SUBJECT: Rock Creek Mesa – SH 115
EPC PCD Ref. No. P209
RE: CDOT Comment Letter Dated April 19, 2021
Response to Comments Memorandum
LSC #184380

Following are the LSC Transportation Consultants, Inc. responses to the April 19, 2021 Comment Letter from CDOT – Region 2 Permits regarding the Rock Creek Mesa Zone Change application (El Paso County PCD Reference No.: P209). CDOT comments are in italics font and LSC responses are noted as such.

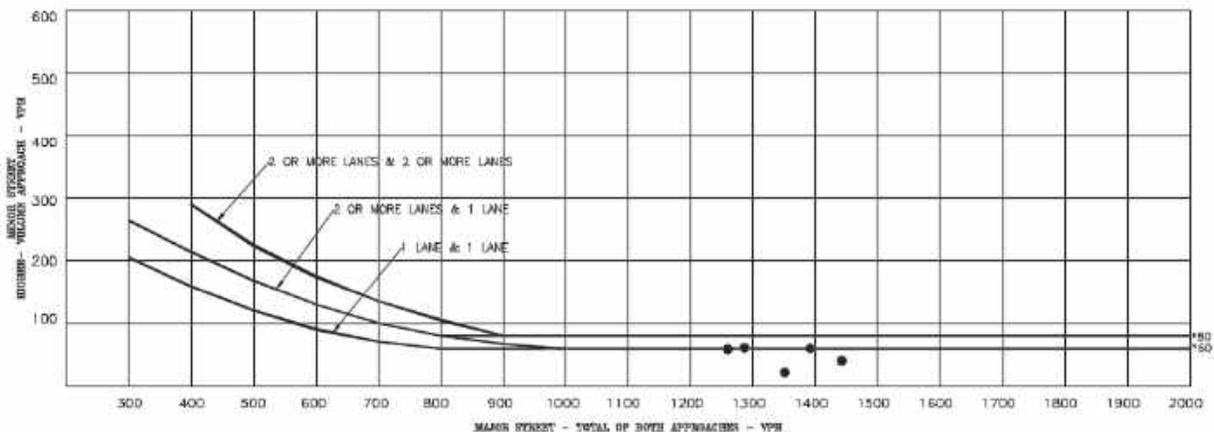
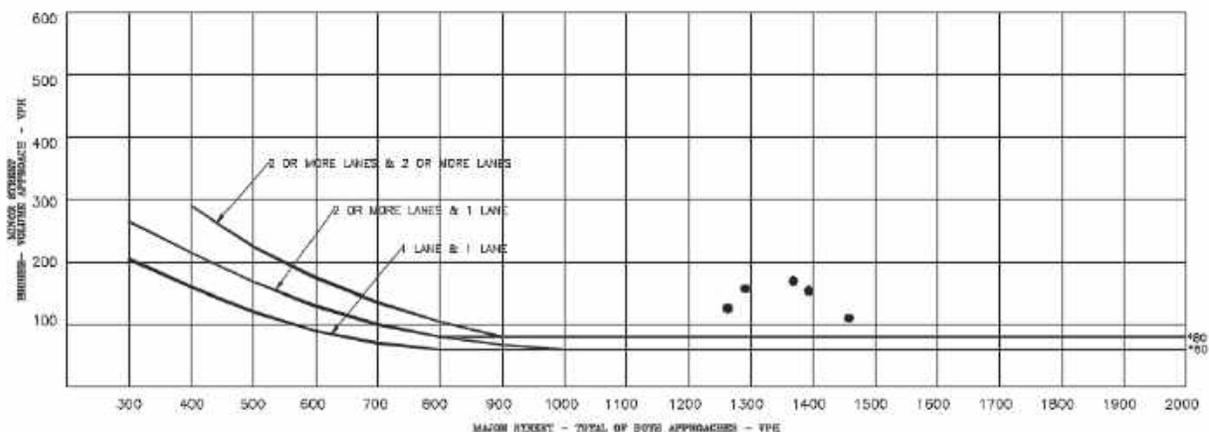
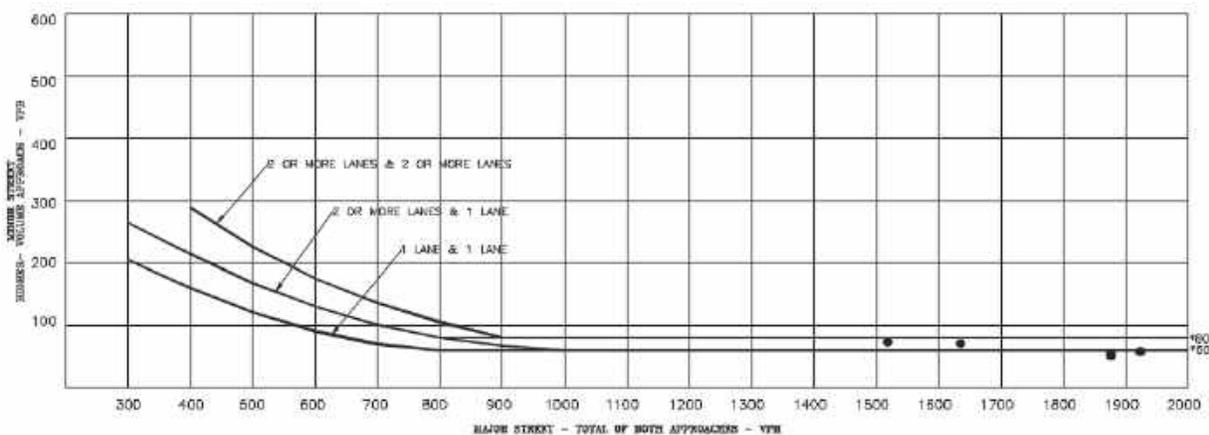
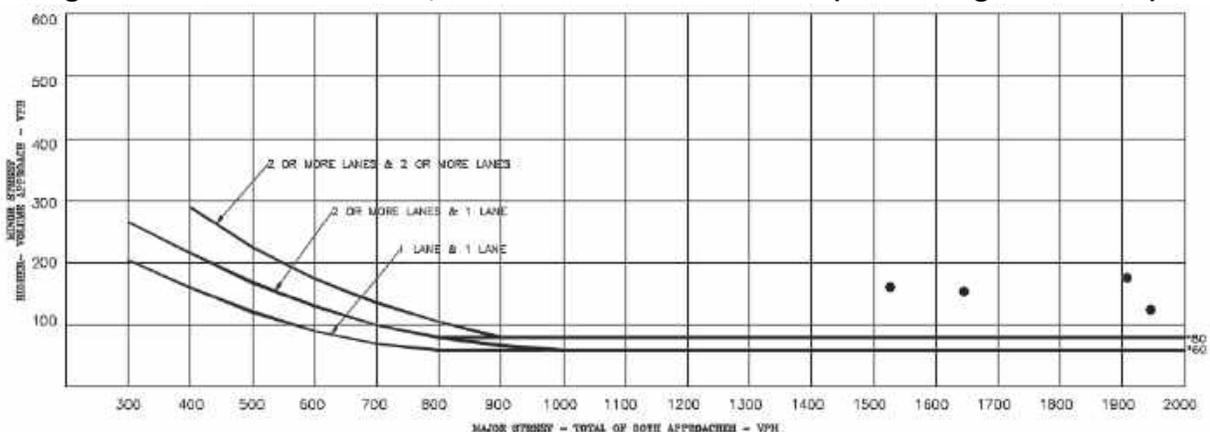
- *Signal warrant analysis of Highway 115 and Pawnee Road should be included in the traffic study.*

LSC Response: The updated TIS report includes the signal-warrant analysis.

Figure 3
Existing Traffic, Lane Geometry,
Traffic Control, and LOS

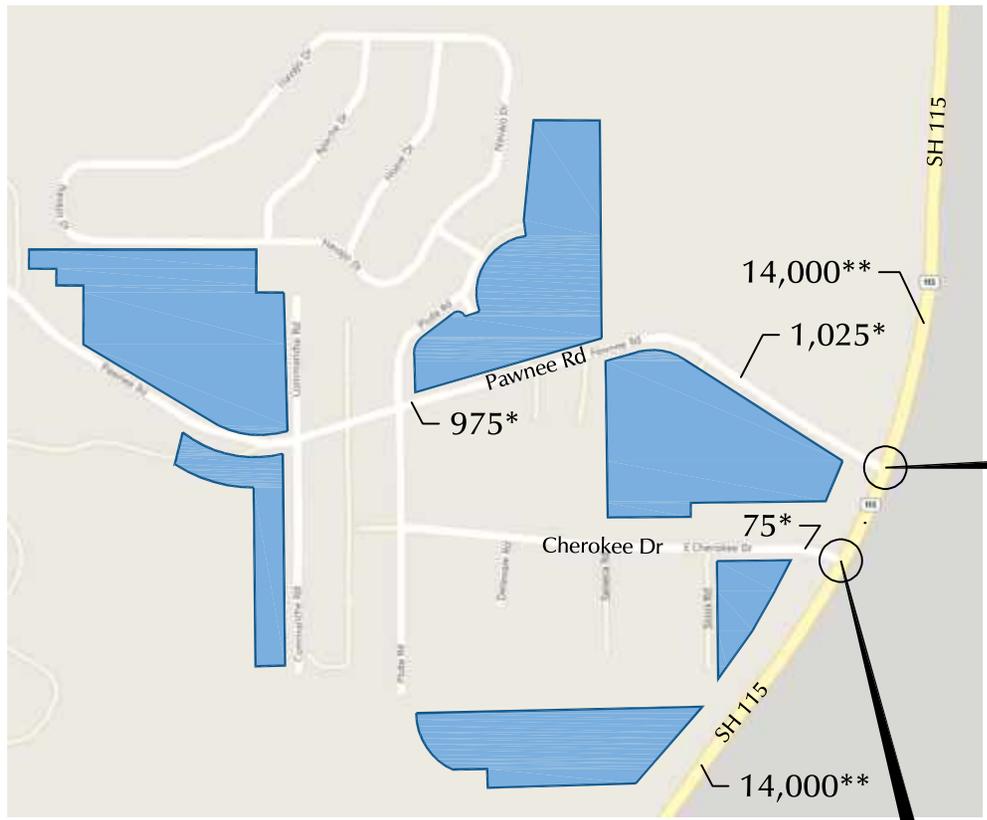
- *Comments below are from 01/11/2021 planning comments.*
 - *The two-way stop control LOS analysis appears to be in error. The LOS for two-way stop is determined by the worst single-movement delay of the intersection. HCM 6th Edition report should be provided in the appendix.*

LSC Response: The updated TIS report includes the HCM 6th Edition reports. Also, the figures show the LOS for the worst single movement – mainly the eastbound left turn at Pawnee/SH 115.
